Town and Country Planning Act 1990 (as amended)
Proposal for Erection of up to 41 Dwellings, Land off School Lane, Forton
Planning Application Number: 20/01296/OUTMAJ

I refer to the report entitled 'Contaminated Land Phase One Desk Study for Clifton House Farm, Clifton Hill, September 2016'. The report has been prepared by Martin Environmental Solutions on behalf of Graham Anthony Associates.

Previous Correspondence

Map Name: County Series

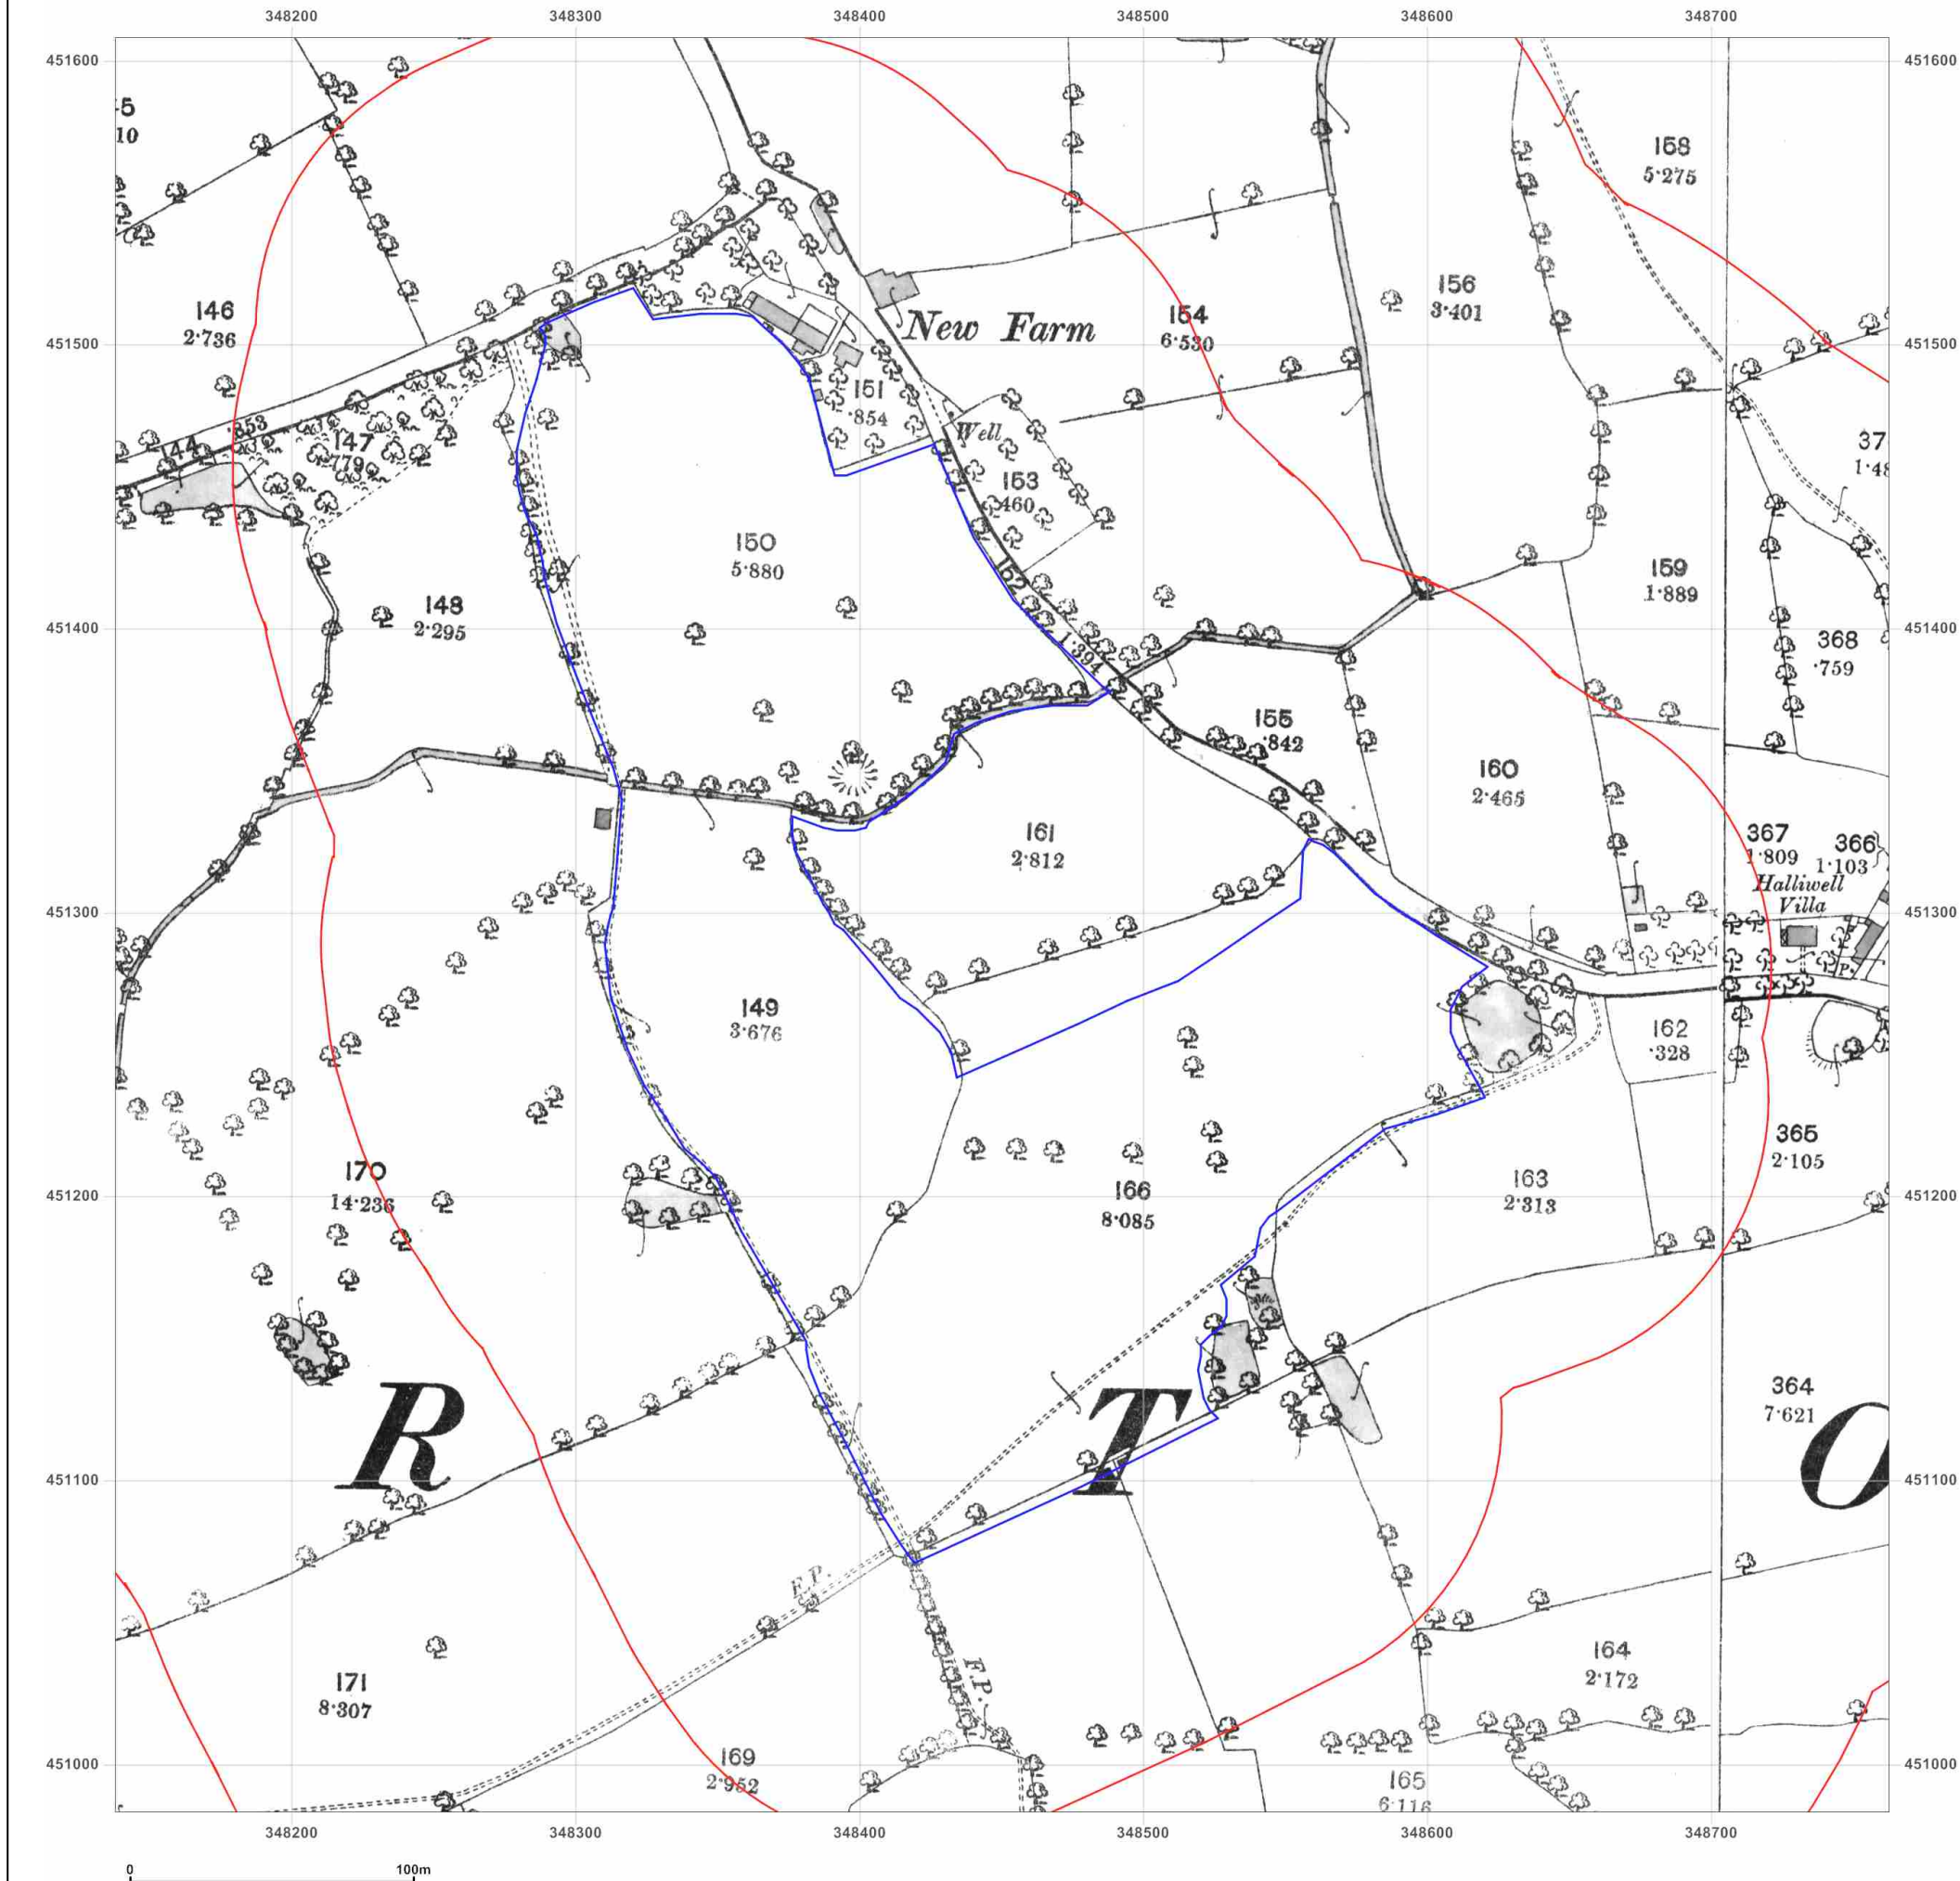
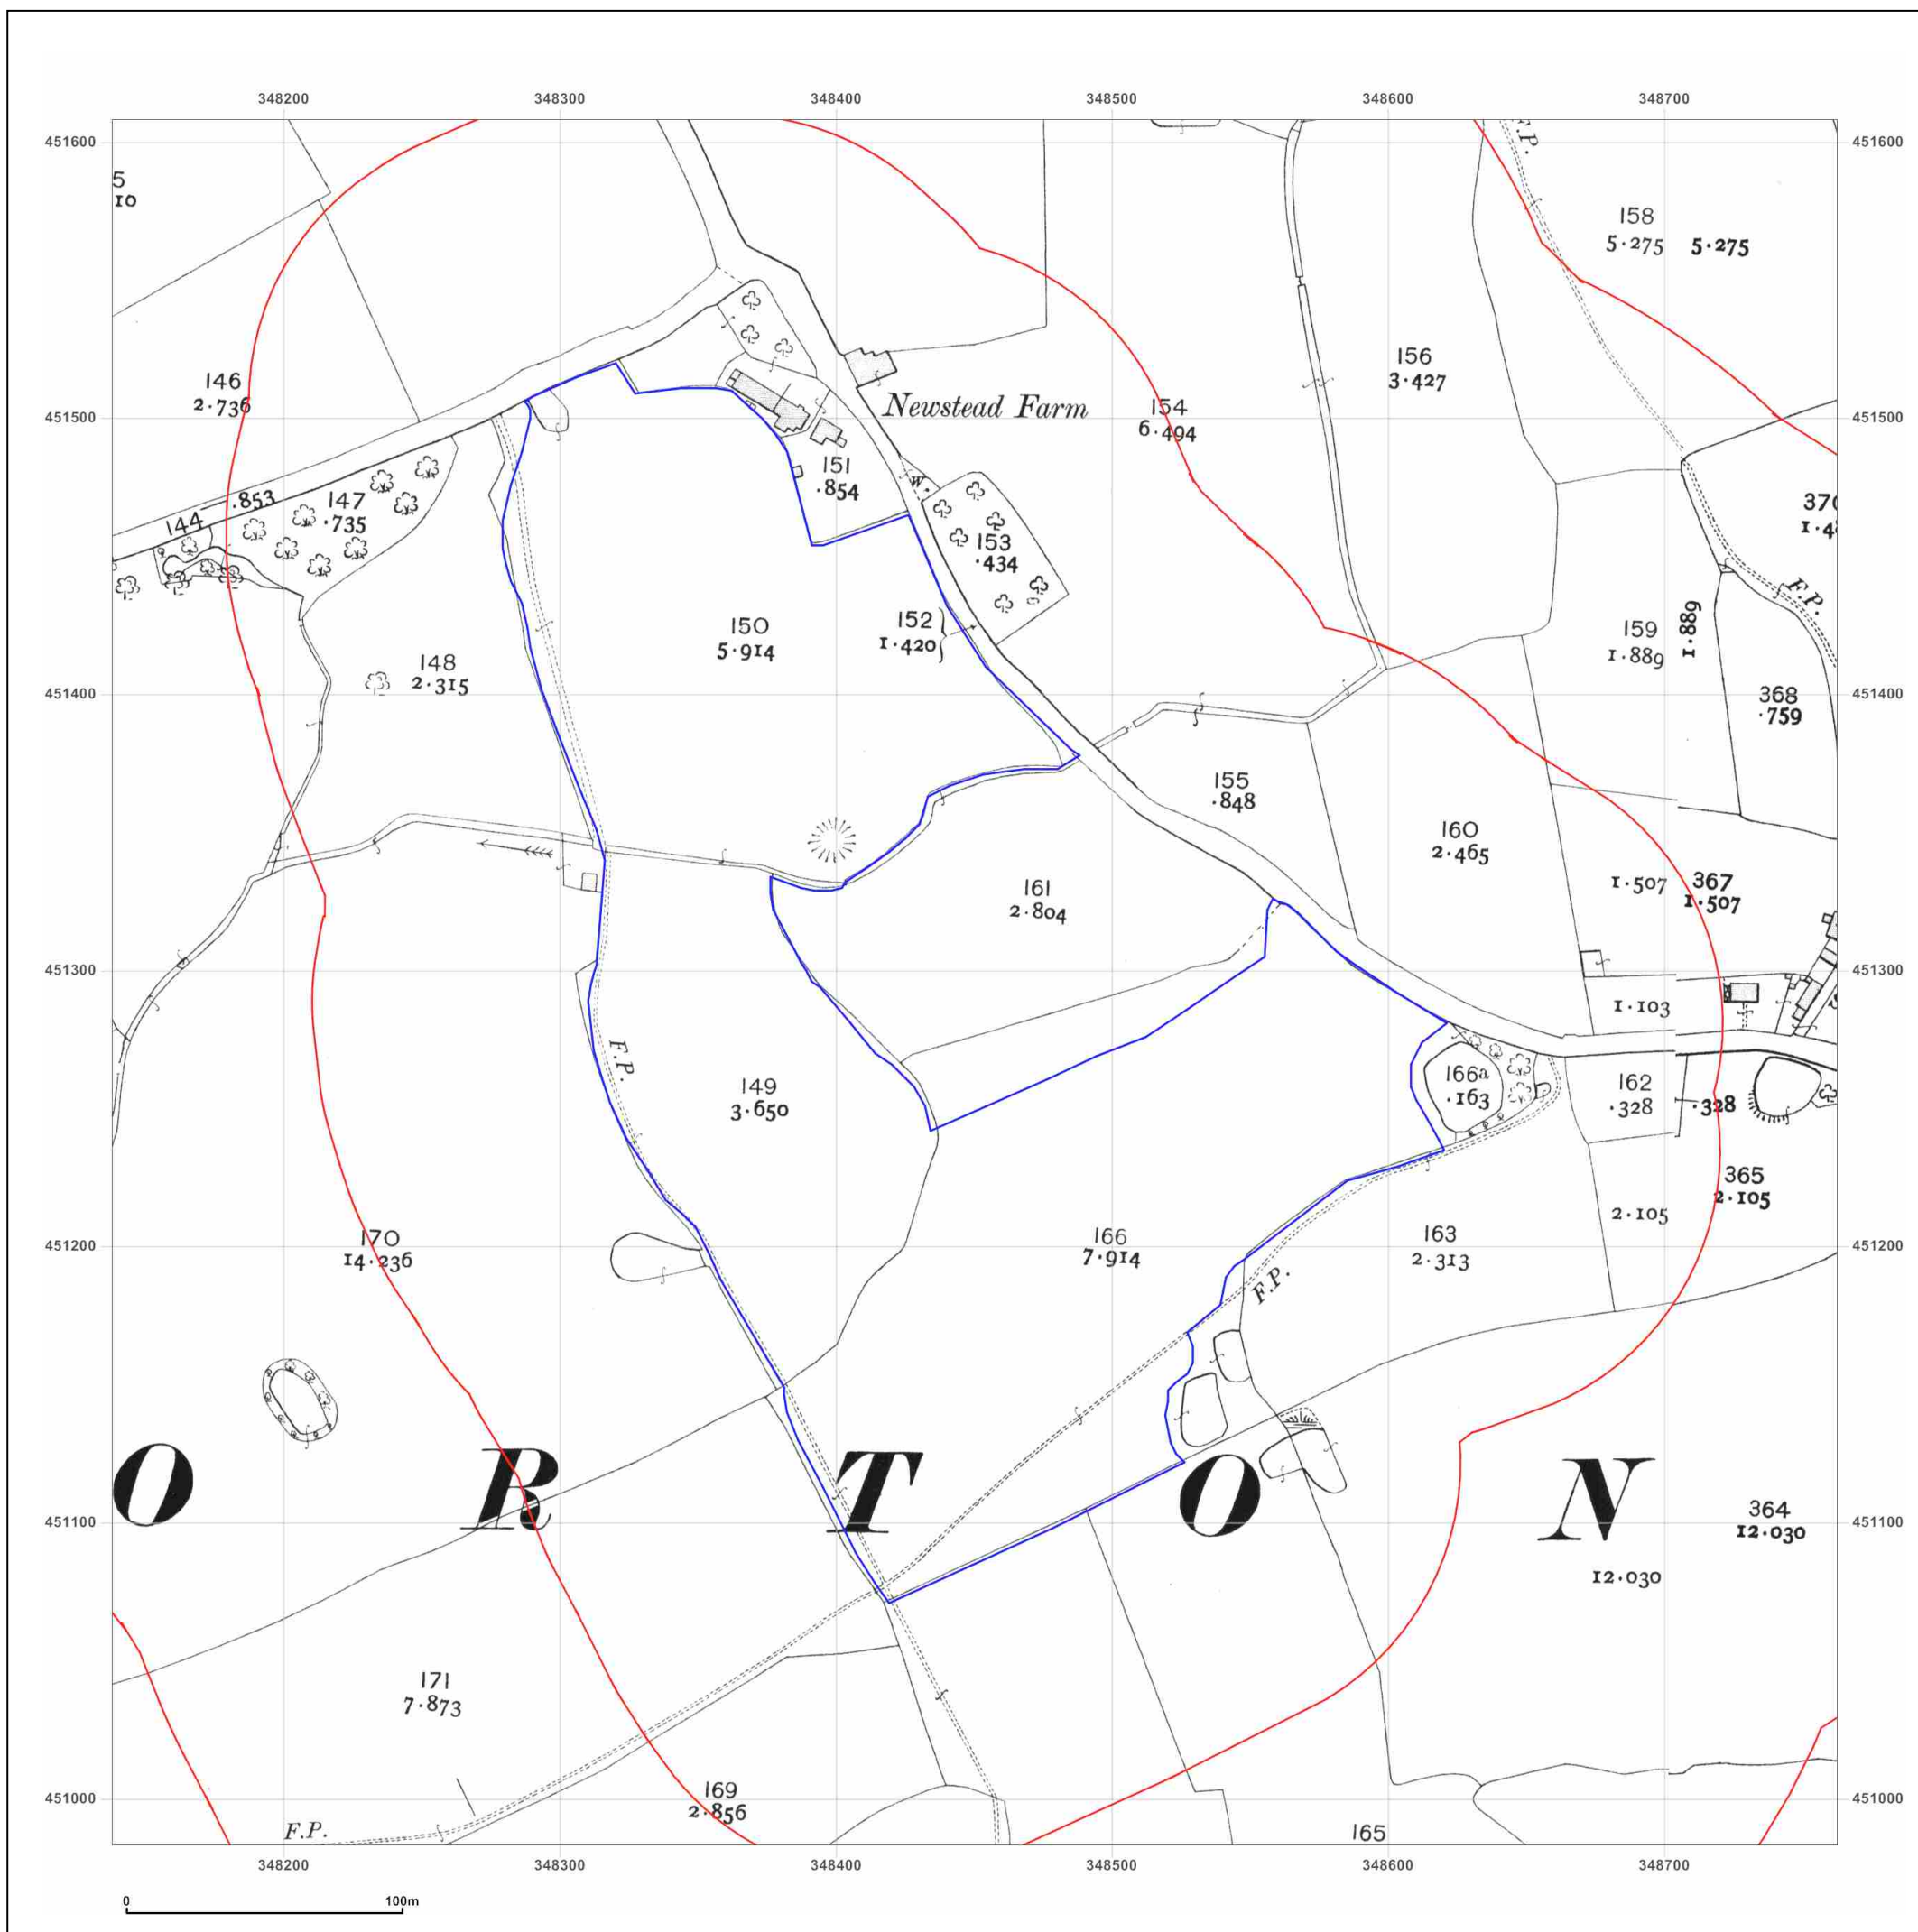
Finally, it is possible that some historical maps are missing from the copy of the report available on line. There is a download for 'appendix 2 historical maps', but the link is for an Ecological Appraisal.

- Please confirm if there are any other historical maps available for review which haven't been uploaded onto the Wyre BC planning portal.
